**Application by East Anglia ONE North Ltd for East Anglia ONE North Offshore Wind Farm.
EN010077 REF 20024721**

**Application by East Anglia TWO Ltd for East Anglia TWO Offshore Wind Farm
EN010078 REF 20024704**

Responses to Examining Authority Written Questions

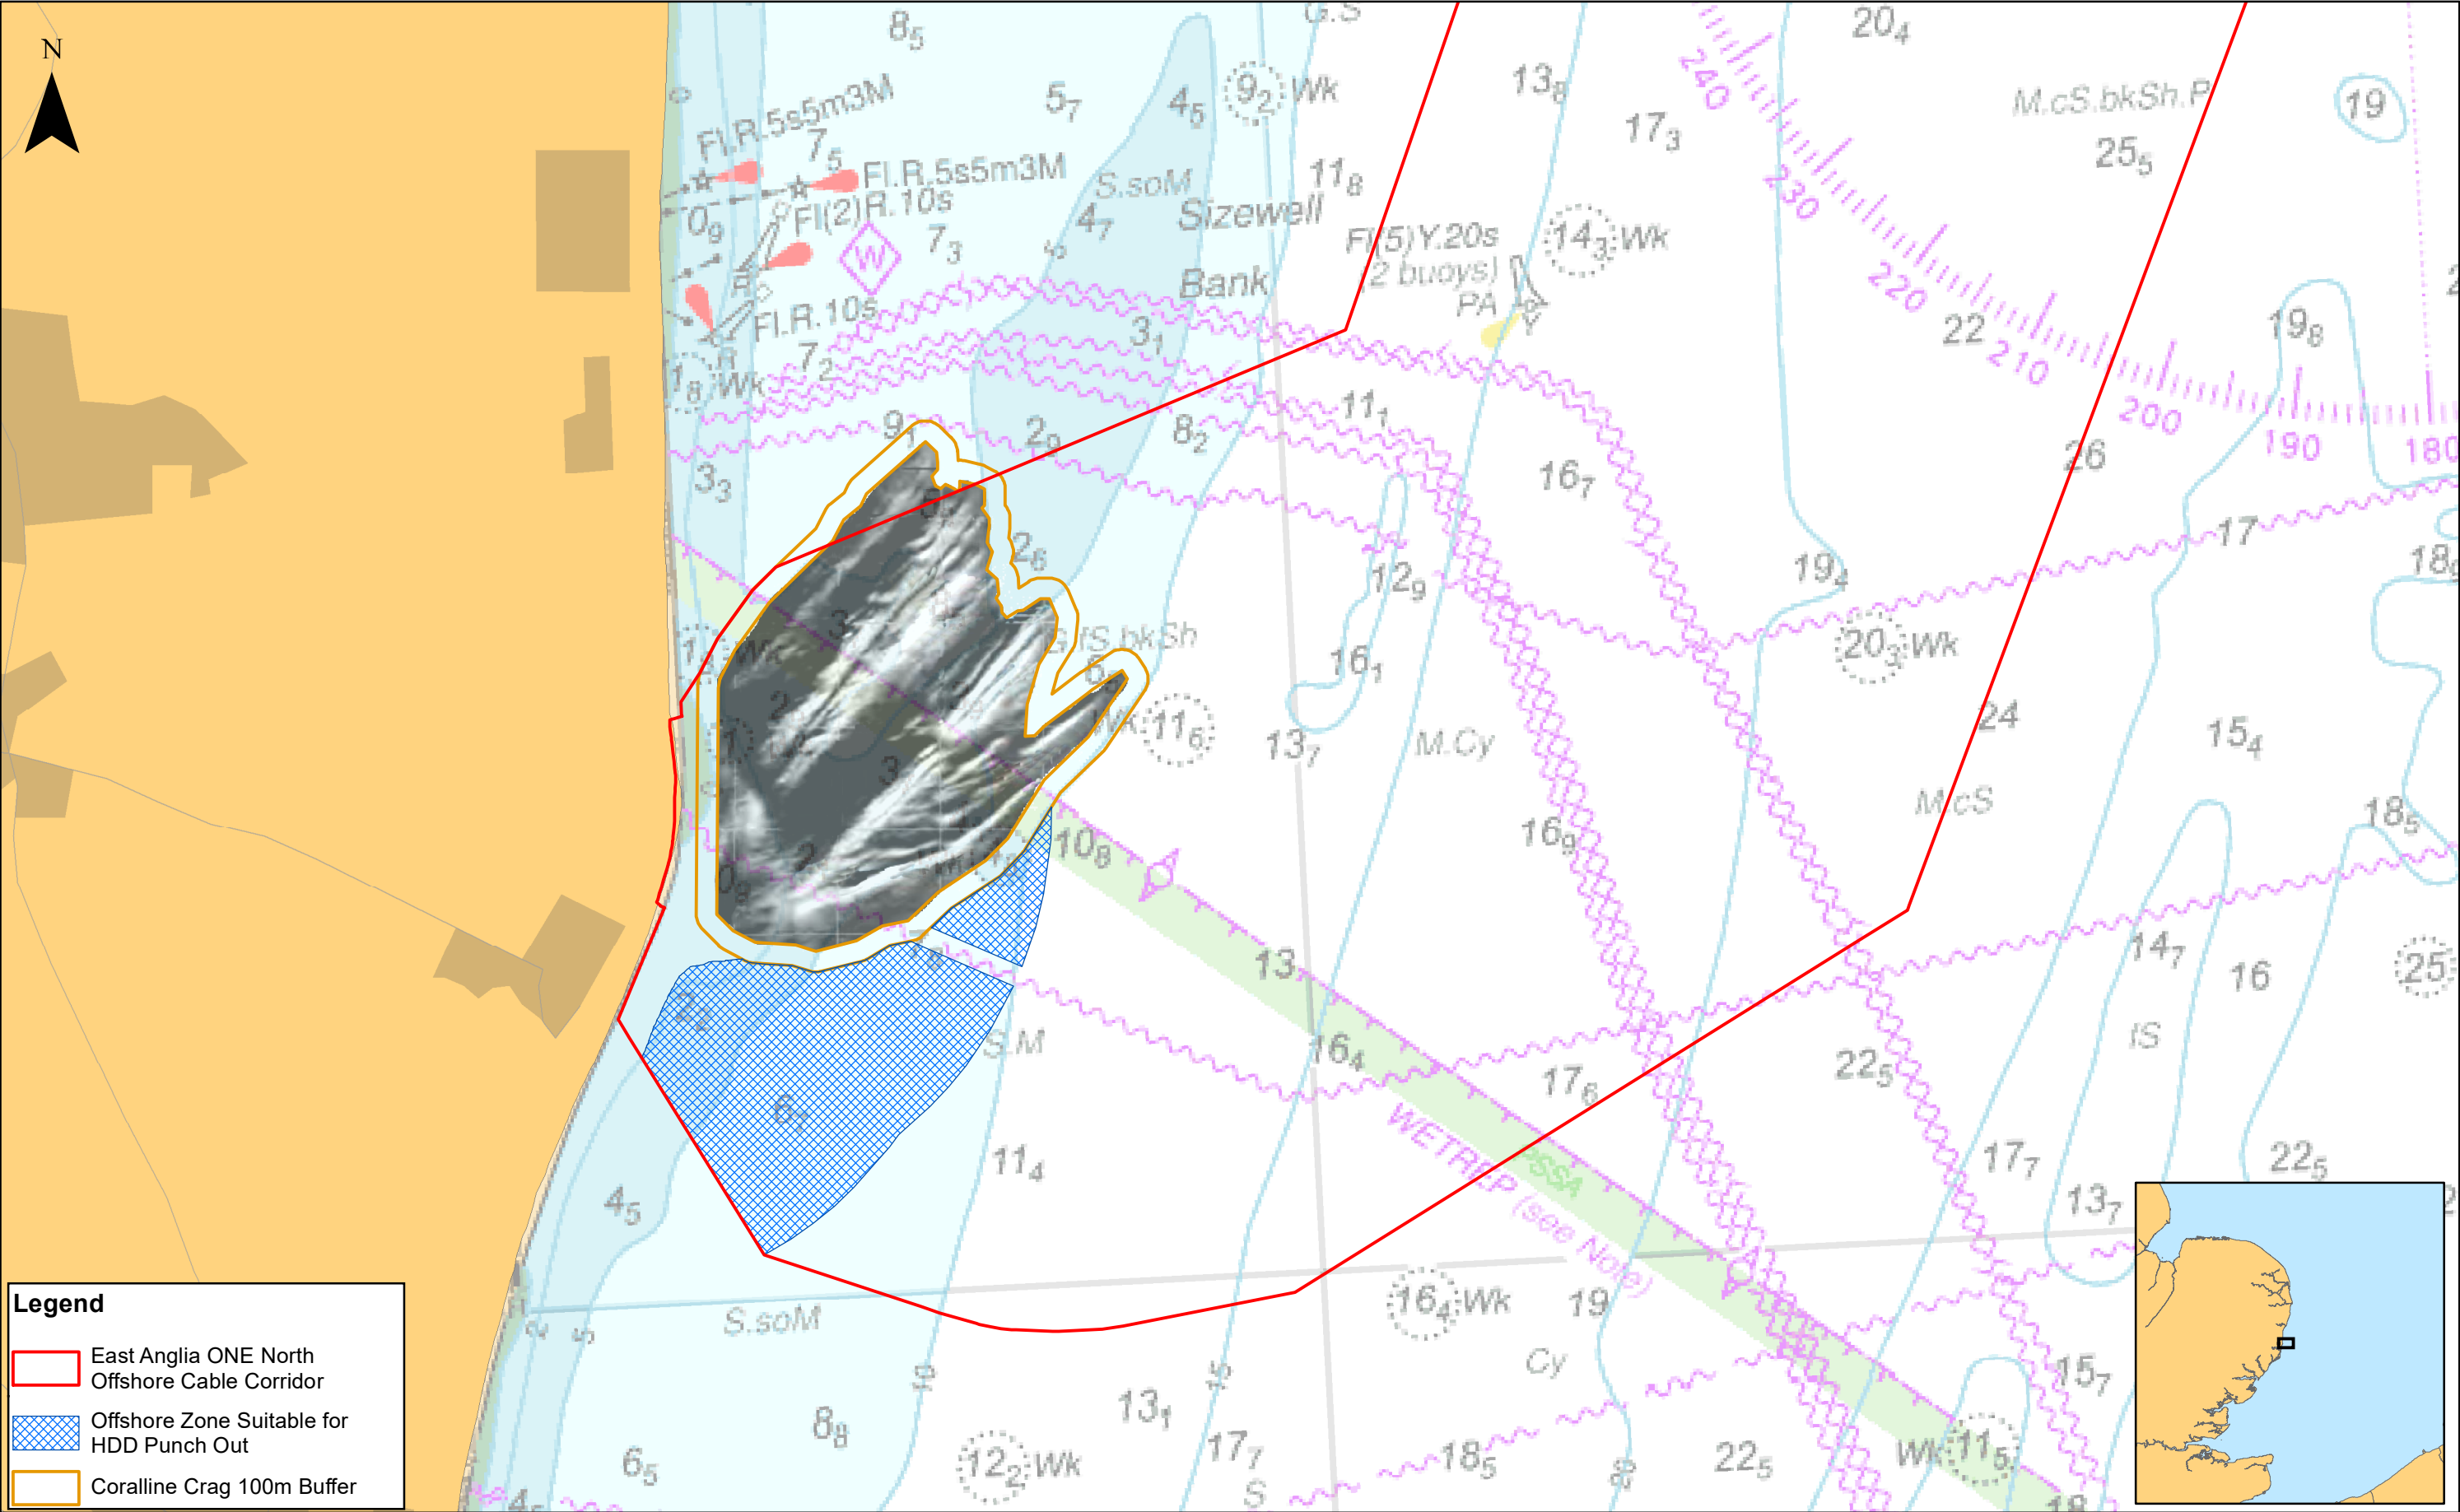
ExA Question Ref	Respondent	ExA Question	EDF Nuclear Energy Generation Ltd Response
			<p>Access Points on the Sizewell Gap Road We understand through engagement on the draft SOCG that an Outline Sizewell Gap Construction Works Method Statement will form part of the Code of Construction Practice under Requirement 22 the draft DCO. At this stage there is no reference in the draft DCO to this requirement. We are currently reviewing this Method Statement with a view to agreeing the extent of works in carriageway of the Sizewell Gap Road and traffic management arrangements to ensure that there is uninterrupted access for all types of vehicles (including cyclists and pedestrians) at all times to reduce the potential impact on access to SZB for both operational and emergency purposes.</p> <p>Utilities We request that the applicant confirms whether works have the potential to interrupt services (water, telecommunications, power supply) to SZB and provide the appropriate protective provisions.</p> <p>Cooling Water Infrastructure The ES states that consideration has been given to the proximity to the Sizewell nuclear power station cooling water infrastructure with respect to tidal streams. This has led to the preference for a location for cable installation towards the southern side of the cable corridor, and an extension of the original corridor further to the south in order to accommodate this. The proposed HDD method and pop-out location reduces the risk of suspended sediment (during construction) affecting the Sizewell Nuclear Power Station’s cooling water infrastructure. No significant impact is reported. We would agree with this assessment but would request inclusion of a commitment in the Order to locate the HDD Punch Out in the area shaded blue and referred to as the “Offshore Zone Suitable for HDD Punch Out” in</p>

ExA Question Ref	Respondent	ExA Question	EDF Nuclear Energy Generation Ltd Response
			<p>Figure 7.7 of the ES and amendment to draft Requirement 13 to require consultation with EDF Nuclear Energy Generation on the submission of the Landfall Construction Method Statement for the construction of Work No. 6.</p> <p>Flood Risk Cumulative impacts with Sizewell B Power Station Complex were assessed as being not significant. We would agree with this assessment.</p> <p>Emergency Planning There is no reference or assessment in the ES of the potential to exacerbate an emergency incident at Sizewell B in the ES, should works to create the new access points on the Sizewell Gap Road impede or prohibit emergency access to Sizewell B. Whilst we welcome the commitment in the draft DCO (Requirement 33) to prepare an Emergency Incident Response Plan, we would ask for further consideration of the potential effects and clear commitment to engage with EDF Nuclear Energy Generation Ltd in developing the Emergency Incident Response Plan.</p> <p>In addition the Applicants must continue to liaise with the Suffolk Joint Emergency Planning Unit to ensure that appropriate updates are made to the Sizewell Off Site Emergency Plan (prepared by the Suffolk Joint Emergency Planning Unit on behalf of Suffolk County Council / Suffolk Resilience Forum) to accommodate the construction, operation and decommissioning of the Projects.</p>
